Observations By:	David Stainsby KC, Highways Development Management
Application No.	2023/91261
Proposed Development:	Erection of two detached dwellings with garages, regrading of land and erection of retaining walls to form access and turning area from Lower Gate
Location:	land at, Alexandra Road West, Paddock, Huddersfield, HD3 4EX
OS Map Reference	SE 412290.3703 416245.6483
Applicant/Agent:	Northlight Architecture Ltd
Class:	Minor Developments

Consultation Response from David Stainsby KC, Highways Development Management
2023/91261 land at, Alexandra Road West, Paddock, Huddersfield, HD3 4EX
Erection of two detached dwellings with garages, regrading of land and erection of retaining walls to form access and turning area from Lower Gate
Date Responded: 17/10/2023. Responding Officer: D. Stainsby Responding Ref: K5-1SW/5

This application is for the erection of 2 detached dwellings with parking and a new access on to Lowergate, a 30mph two-way single carriageway local link road of approximately 6.3m width with footways on both sides and street lighting present.

Scale: @ A1  
**1:100**  
Date  
**Apr '23**  
Drawing no  
**20.1127/(AL)40**  
Drawn by  
**CG**  
App'd  
**-**  
Rev  
**A**

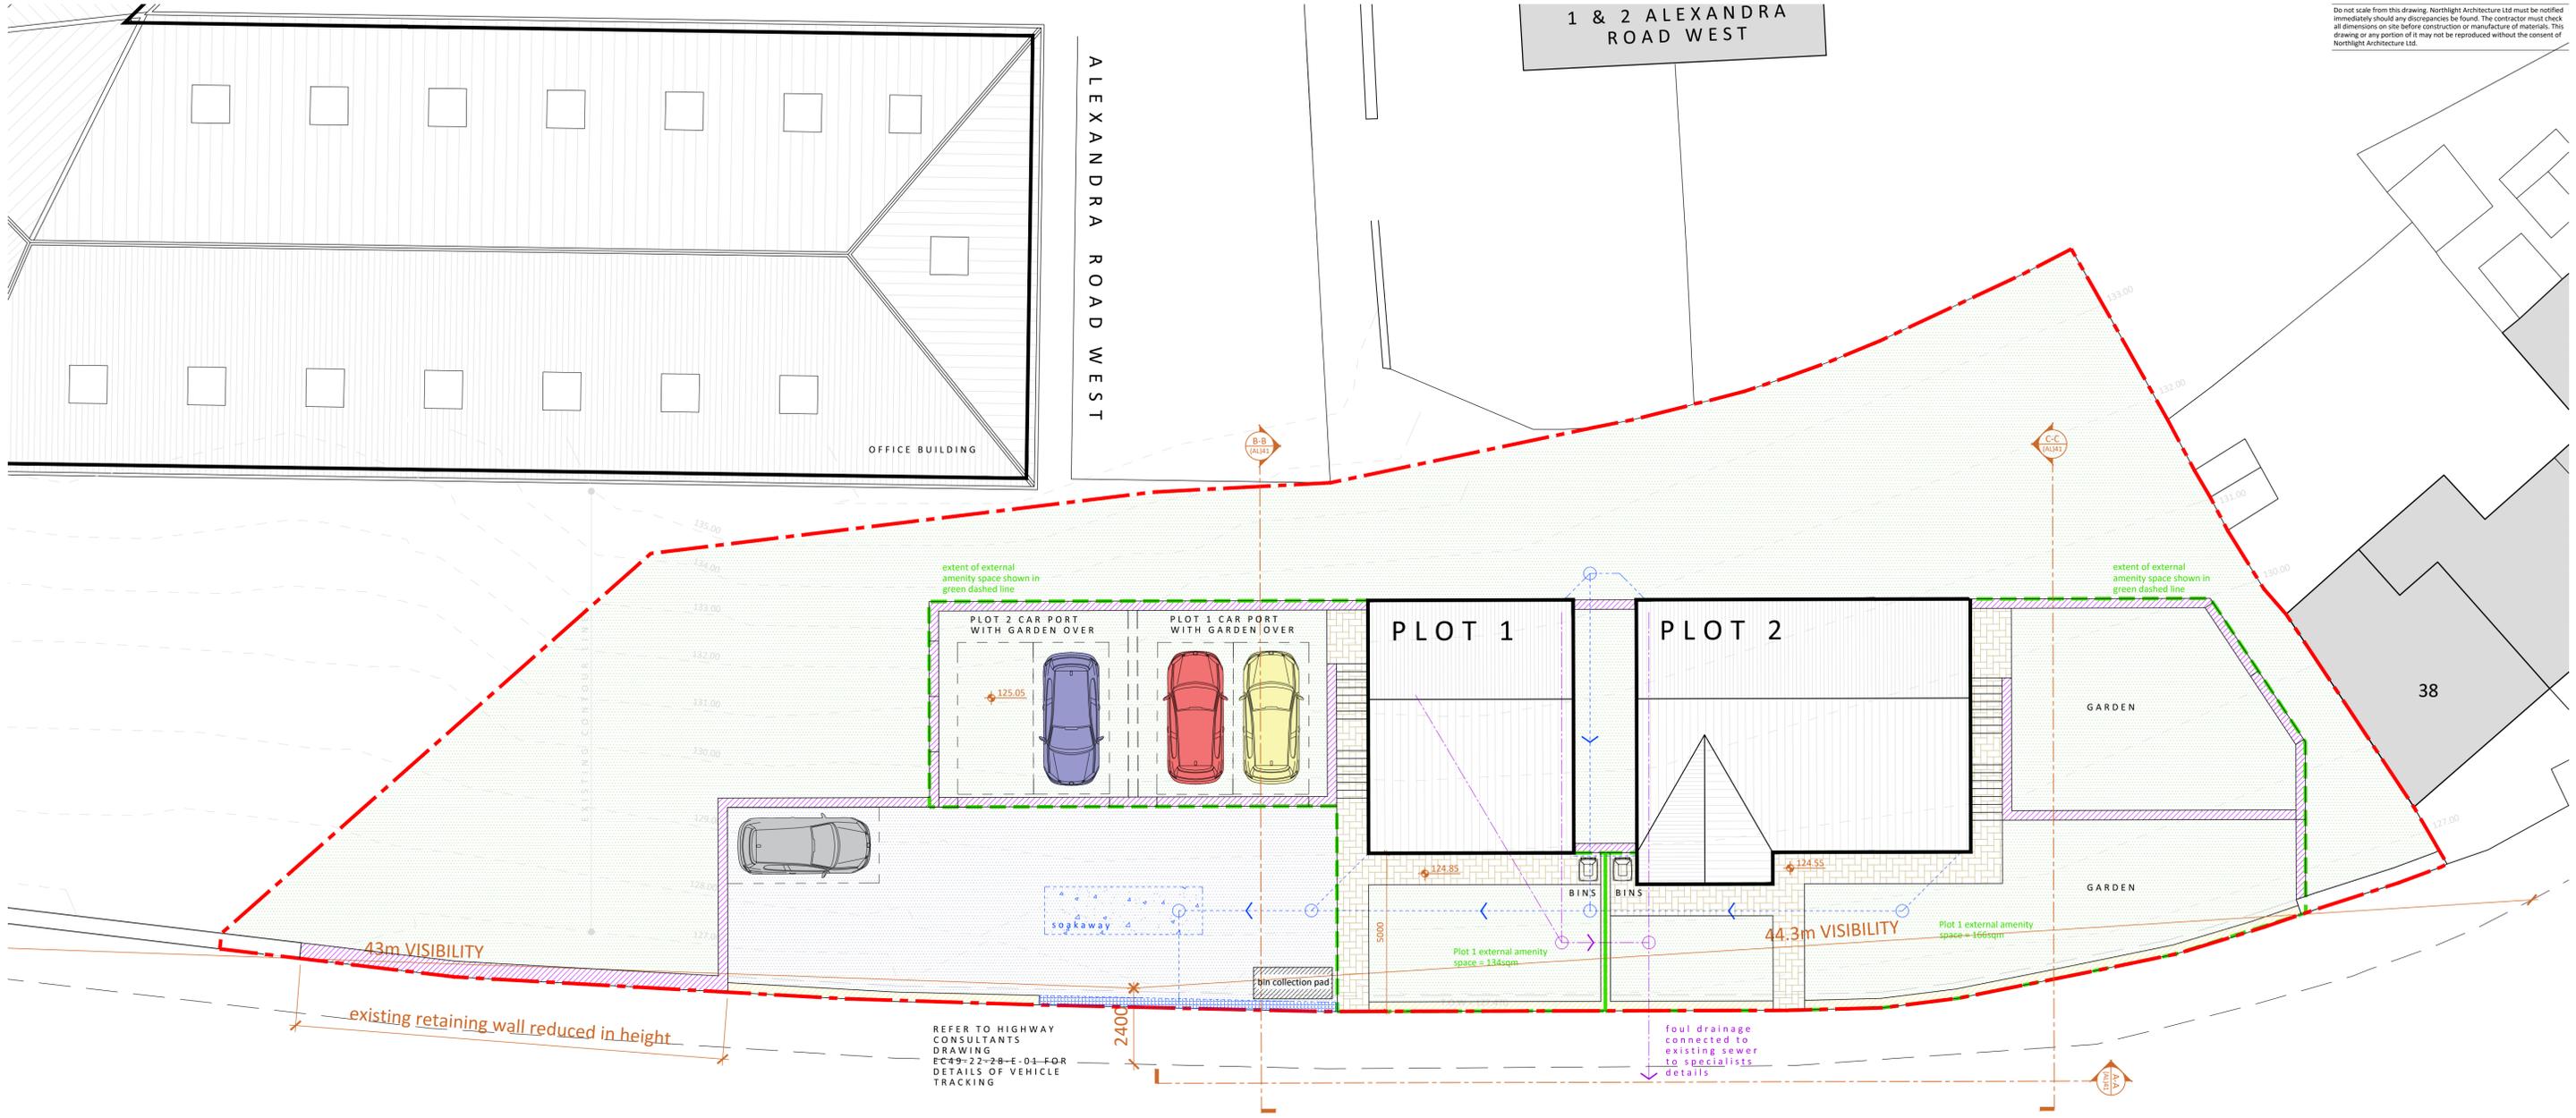
A swept path analysis to show that these vehicles can turn to leave the site in forward gear and details of waste storage and collection for both dwellings have now been provided.

The vehicular crossing shall not be brought into use until the existing telegraph pole and access chamber has been relocated to a location which must be agreed by the appropriate authority and does not obstruct vehicle turning movements into the proposed parking area.

The sightlines of 2.4m x 43m along Lowergate, as shown on the approved plan, shall be cleared of all obstructions to visibility exceeding 0.9 m in height and these shall be retained free of any such obstruction throughout the lifetime of the development.

Details of waste storage and collection for both dwellings have now been provided.

It should be noted that the collection of the bins from this location would be acceptable as there is an exemption from the double white centre-line TRO for municipal waste collection, however I've been advised by the Kirklees cleansing department that if there are issues with collecting adjacent to a solid white centreline, they may request that the bins are offered for collection from the car park, beyond the end of the double white centrelines
